Ribble Valley Borough Council
Planning Section
Council Offices
Church Walk
Clitheroe
BB7 2RA

Location: Bolton Fold Farm, Alston Lane, Longridge, PR3 3BN

Proposal: Proposed erection of additional cow cubicle

PROPOSED SITE PLAN

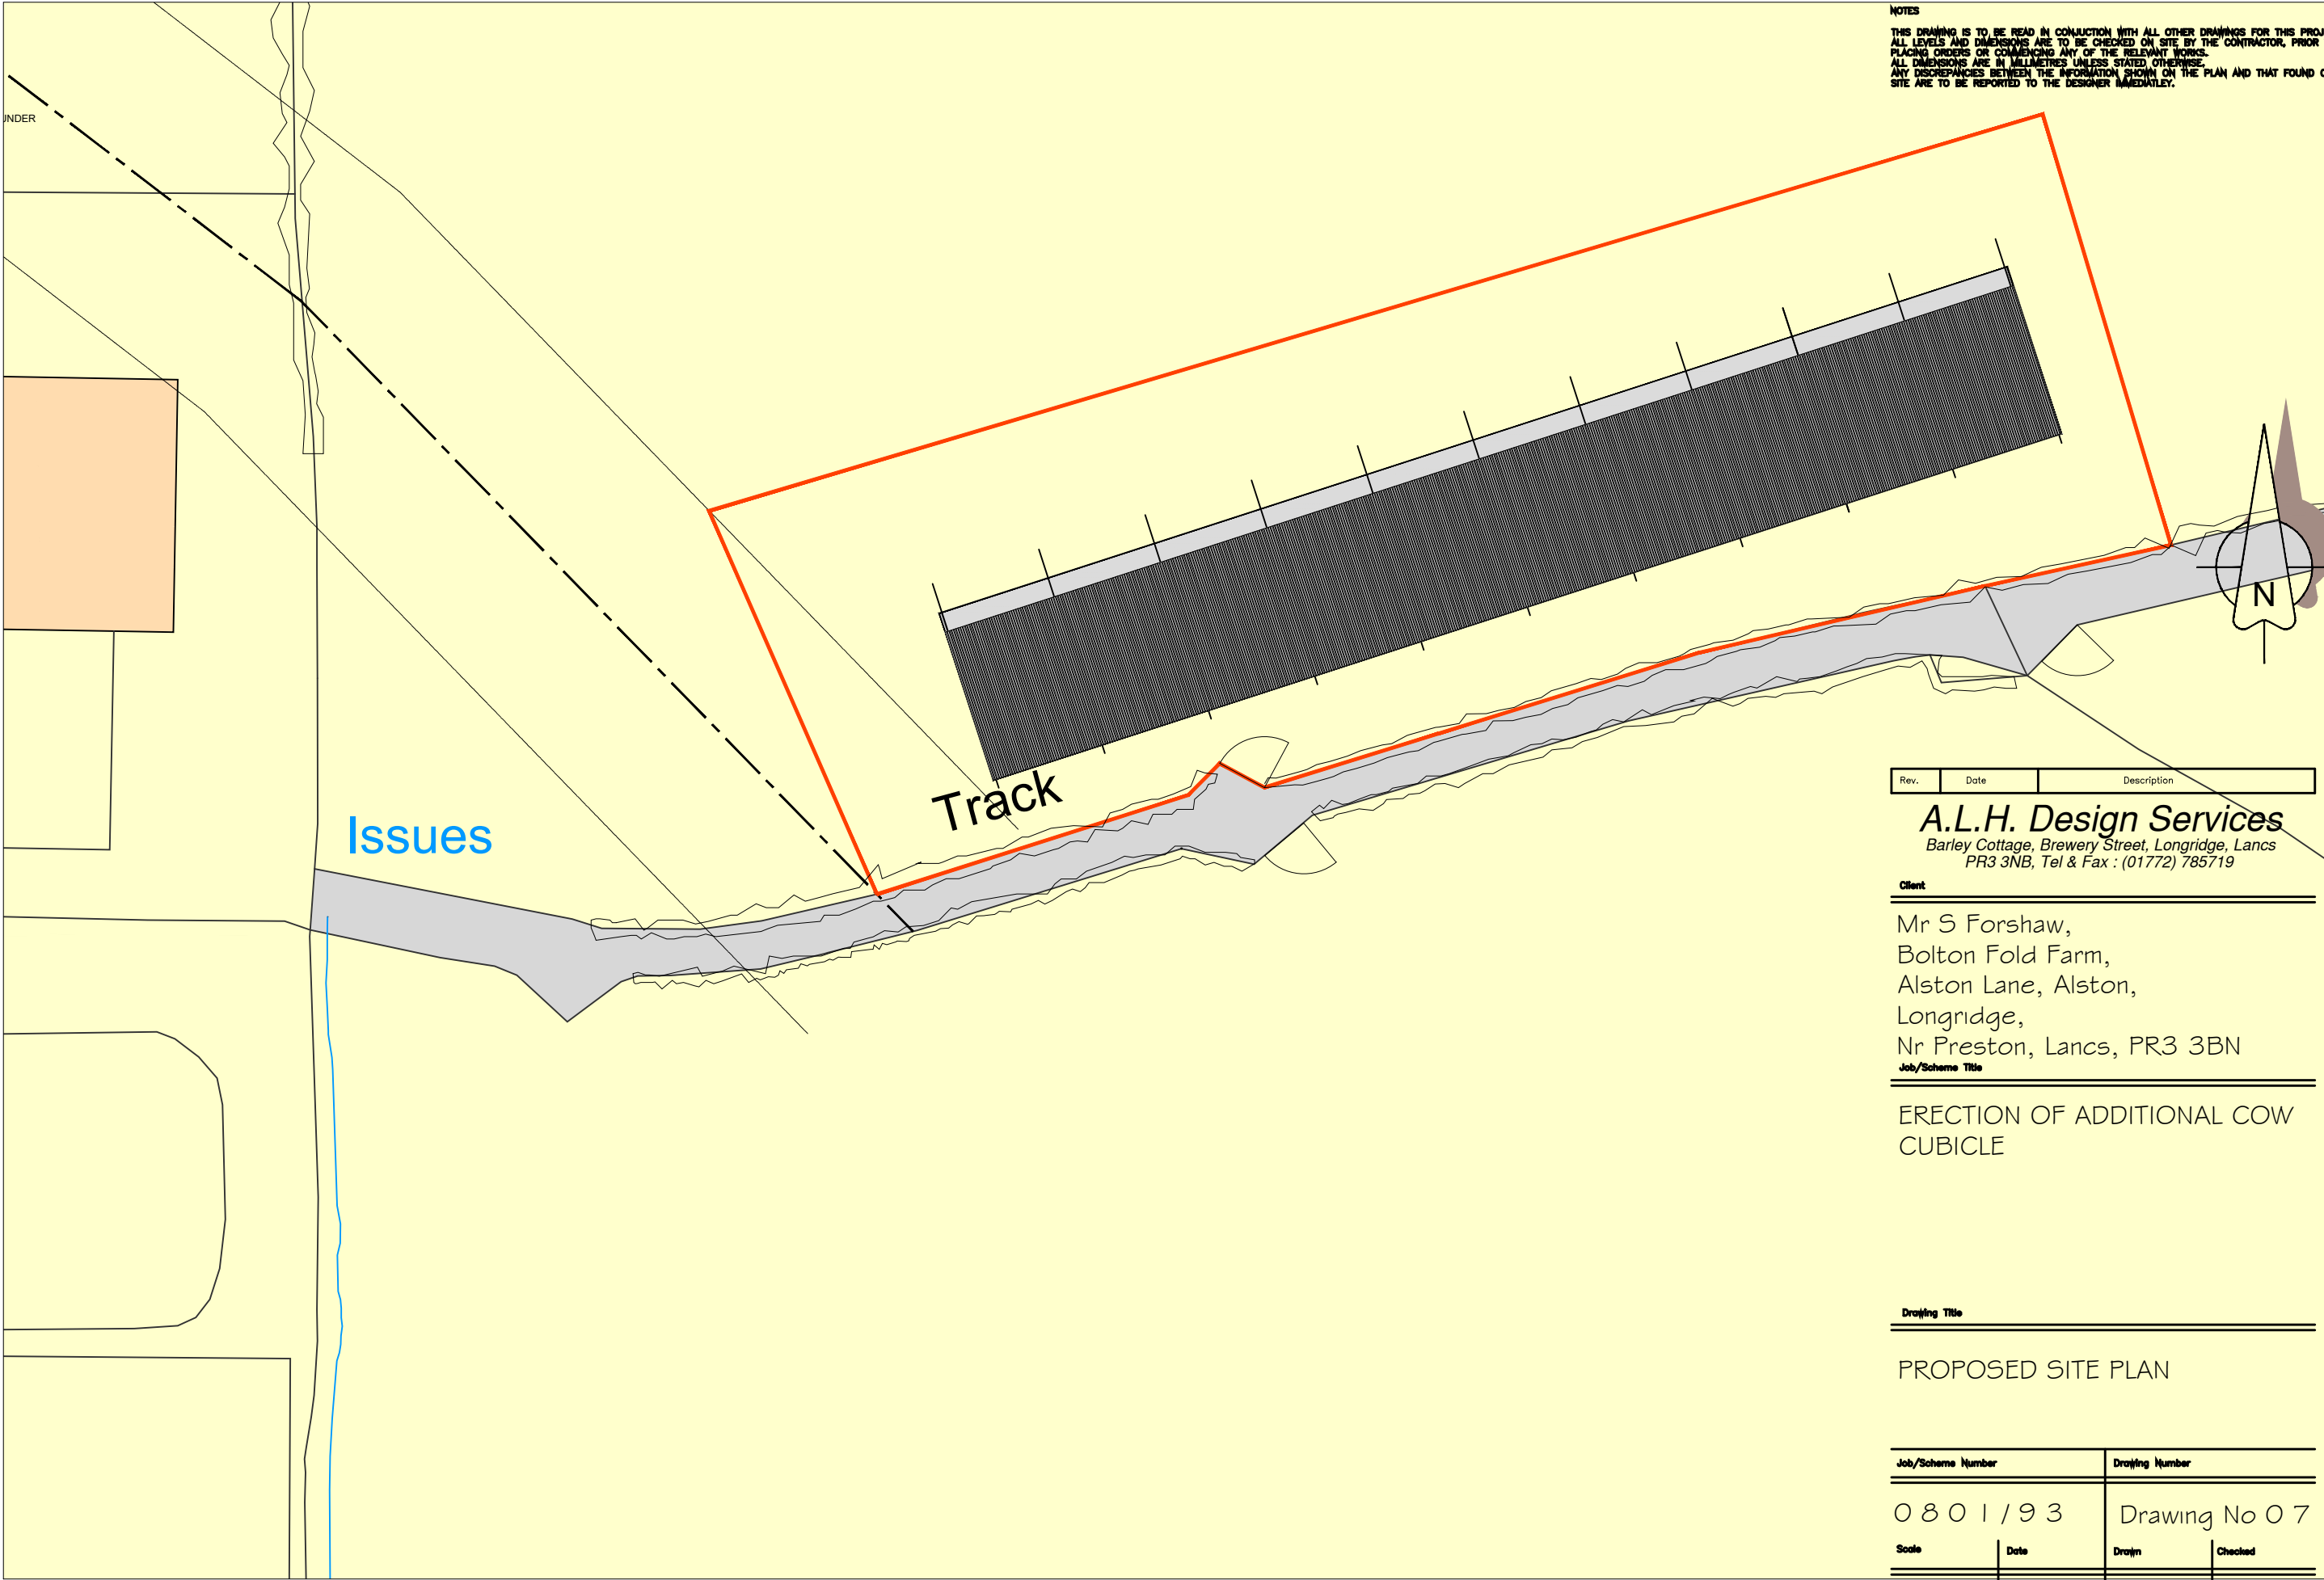
Public Right of Way (PRoW) footpath's FP0302069 and FP0302068 run through the site and adjacent the proposed cow cubicle. PRoW footpaths must remain clear and free from construction works at all times.
